Rosefield Solar Farm

Schedule of Changes to the draft DCO (Tracked)

EN010158/APP/3.1.88-1.7
Revision 037
Deadline 65
JulyAugust 2026
Rosefield Energyfarm Limited

Schedule of Changes to the draft DCO

**SHEET 1 OF 8**

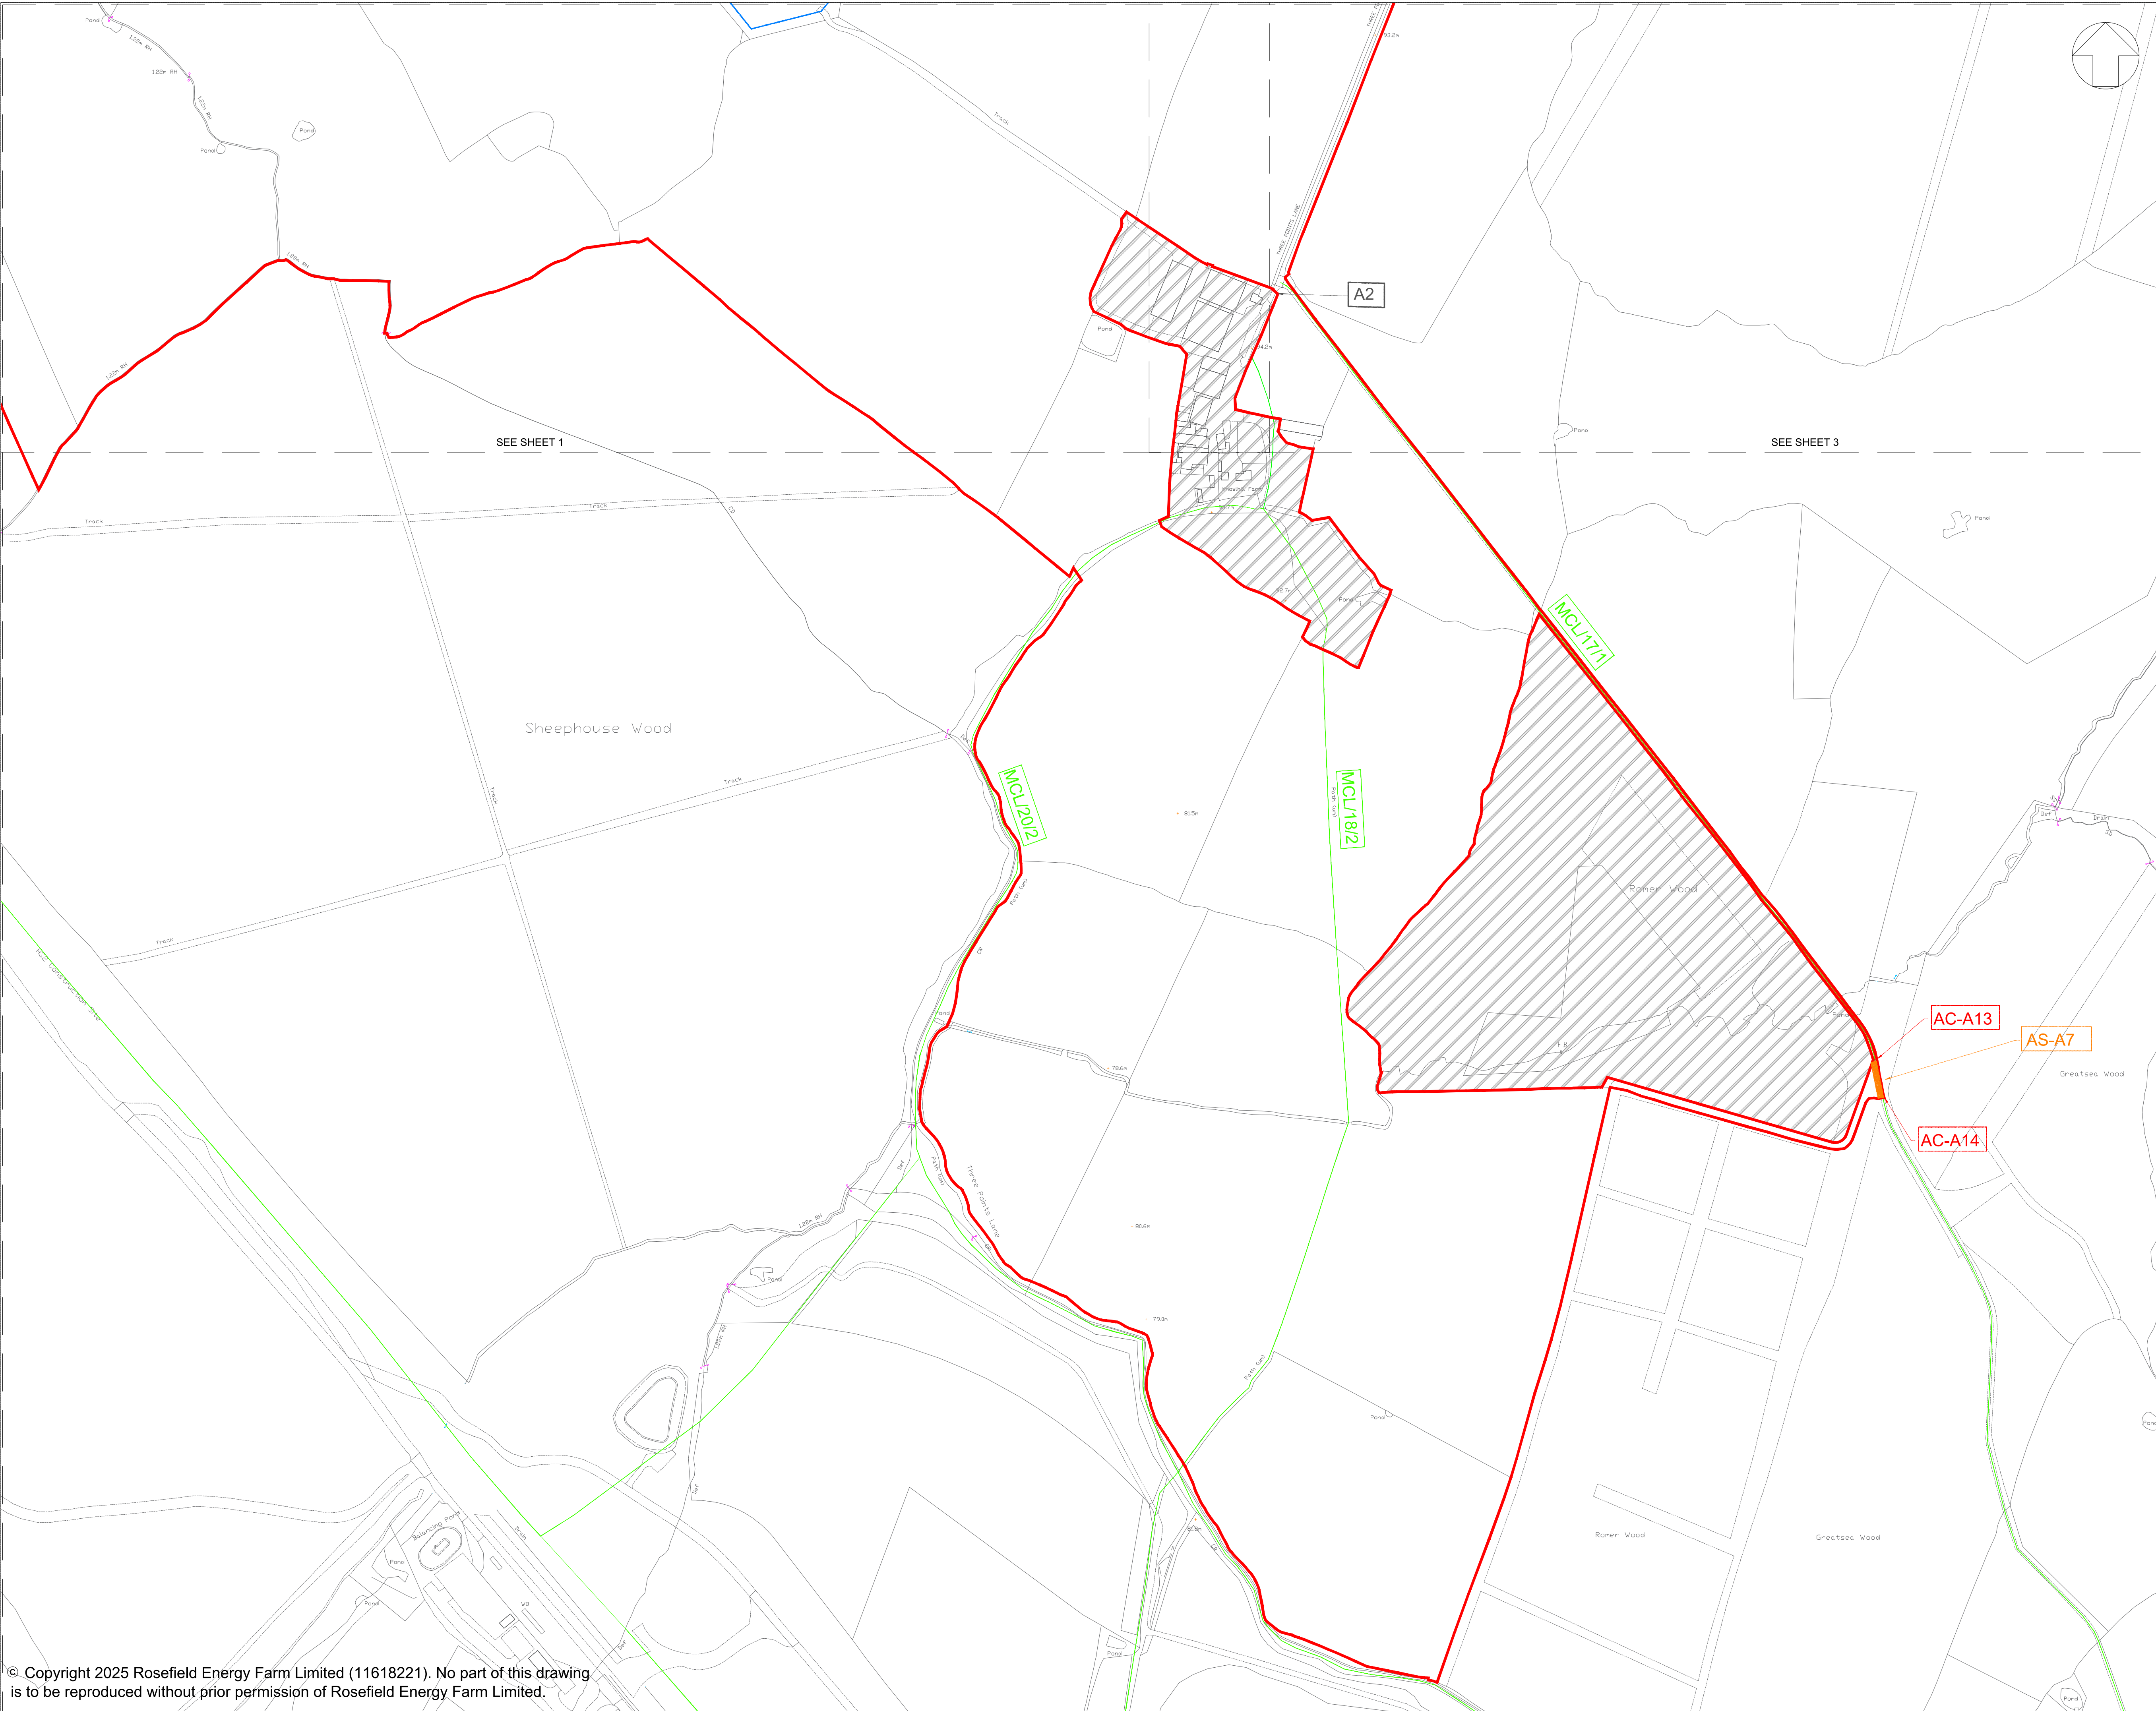
Reference	Change	Reason for Change	Deadline								
	Environment Agency and Anglian Water Services Limited or its successor in function as the relevant water undertaker. (2) The written details under sub-paragraph (1) must be substantially in accordance with the outline drainage strategy. (3) Any approved strategy must be implemented as approved and maintained throughout the construction and operation of the authorised development.	representation [RR-081] and AWS' relevant representation [RR-012], where each requested to be a consultee.									
Schedule 2, Requirement 14 (Operational noise)	14. – (1) No part of Work Nos. 1 to 5 may commence until an operational noise assessment containing details of how the design of that numbered work has incorporated mitigation to ensure the operational noise rating levels as set out in paragraph 13.9.19 of chapter 13 of the environmental statement are complied with for that part has been submitted to and approved by the relevant planning authority.	Addition of reference to more specific operational noise limits on the face of dDCO.	1								
Schedule 6, Part 1 (PRoW to be permanently stopped up and diverted)	<table border="1"> <tr> <th>(1) Area</th><th>(2) Public right of way to be stopped up</th><th>(3) Extent of stopping up</th><th>(4) New public right of way to be substituted / provided</th></tr> <tr> <td>District of Buckinghamshire</td><td>SCL/12/2</td><td>For a distance of 320 190 metres between points PE-A7 PE-A10 and point SW04 as shown on sheet 1 of the streets, access</td><td>New public footpath to be provided between points PE-A7, PE-A5 and its intersection with SCL/12/1 as shown by a cyan line on sheet 1 of</td></tr> </table>	(1) Area	(2) Public right of way to be stopped up	(3) Extent of stopping up	(4) New public right of way to be substituted / provided	District of Buckinghamshire	SCL/12/2	For a distance of 320 190 metres between points PE-A7 PE-A10 and point SW04 as shown on sheet 1 of the streets, access	New public footpath to be provided between points PE-A7, PE-A5 and its intersection with SCL/12/1 as shown by a cyan line on sheet 1 of	Reduction in extent of stopping up to SCL/12/2 to address Buckinghamshire Council's relevant representation [RR-026] to avoid creation of a 'dead-end'.	1
(1) Area	(2) Public right of way to be stopped up	(3) Extent of stopping up	(4) New public right of way to be substituted / provided								
District of Buckinghamshire	SCL/12/2	For a distance of 320 190 metres between points PE-A7 PE-A10 and point SW04 as shown on sheet 1 of the streets, access	New public footpath to be provided between points PE-A7, PE-A5 and its intersection with SCL/12/1 as shown by a cyan line on sheet 1 of

<table><tr> <th>(1) <i>Area</i></th><th>(2) <i>Public right of way to be stopped up</i></th><th>(3) <i>Extent of stopping up</i></th><th>(4) <i>New public right of way to be substituted / provided</i></th></tr><tr> <td>District of Buckinghamshire</td><td>SCL/13/1 and SCL/13/2</td><td>For a distance of 1,210 metres between points PE-A7 and PE-A3 as shown on sheet 1 of the streets, access and rights of way plans.</td><td>New public footpath of minimum width of 2m to be provided between points PE-A7, PE-A5 and PE-A4 and PE-A3 as shown by a cyan line on sheet 1 of the streets, rights of way and access plans.</td></tr><tr> <td>District of Buckinghamshire</td><td>SCL/12/2</td><td>For a distance of 190 metres between points PE-A7 and point PE-A10 as shown on sheet 1 of the streets, access and rights of way plans.</td><td>New public footpath of minimum width of 2m to be provided between points PE-A7, PE-A5 and its intersection with SCL/12/1 as shown by a cyan line on sheet 1 of the streets, rights of way and access plans.</td></tr></table>
